Application for Planning Permission for Works or Extension to a Dwelling

Development: Erection of single storey rear extension.
Location: 1 Acre Close Rustington BN16 3PG

I regret that I am unable to accept your documents as a valid application until the following item(s) have been received or resolved :-

PROPOSED BLOCK PLAN SCALE 1:500

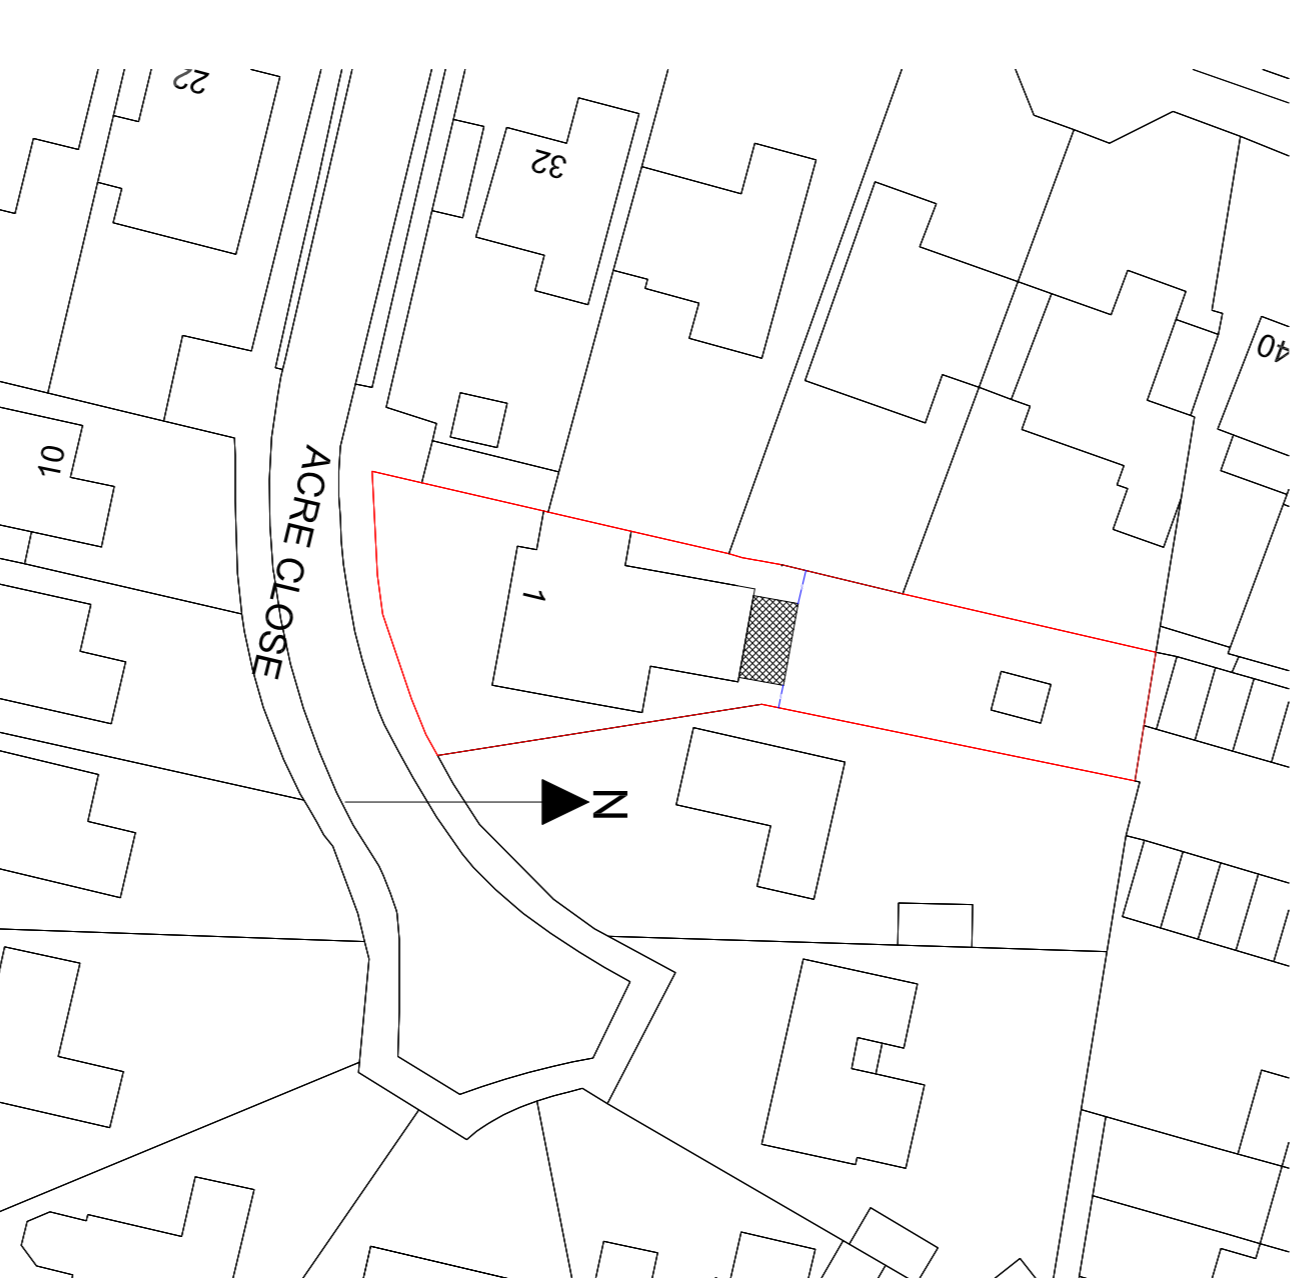
Block Plan

You are required to have dimensions from the proposed extension(s) to all site boundaries. Please amend.
